3/2011/0934

10 January 2012

**STONYHURST COLLEGE (HISTORIC LIBRARIES), HURST GREEN, CLITHEROE,
LANCASHIRE, BB7 9PZ**

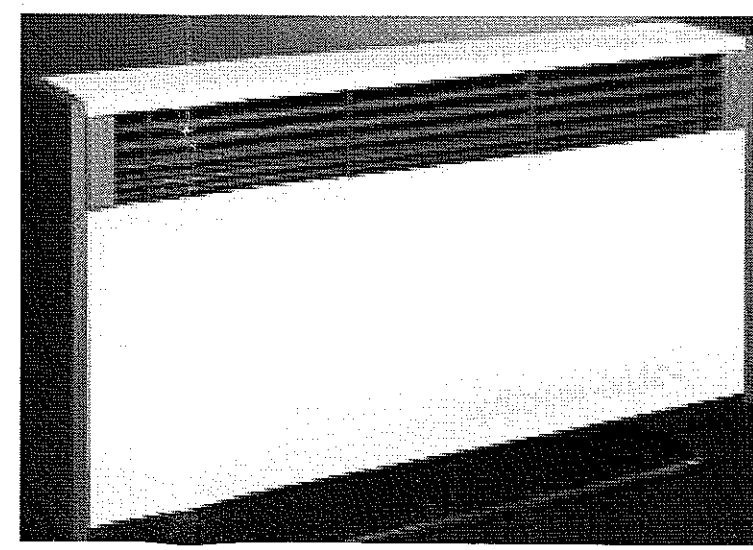
- The dehumidification proposal has been omitted from the Application.
- A smaller heater installation is proposed to the plinths of book cases as shown on drawing No 009.047.M2.
- Double glazing will not be installed in the window frames; the existing double glazing will be removed. All windows will be replaced with single glazing with a UV filter applied to the inside face set into metal window frames. Where possible existing historic glass will be retained, or accommodated into complete windows.
- The nine suspended light fittings in the Square Library are to be omitted; table lamps will be provided.
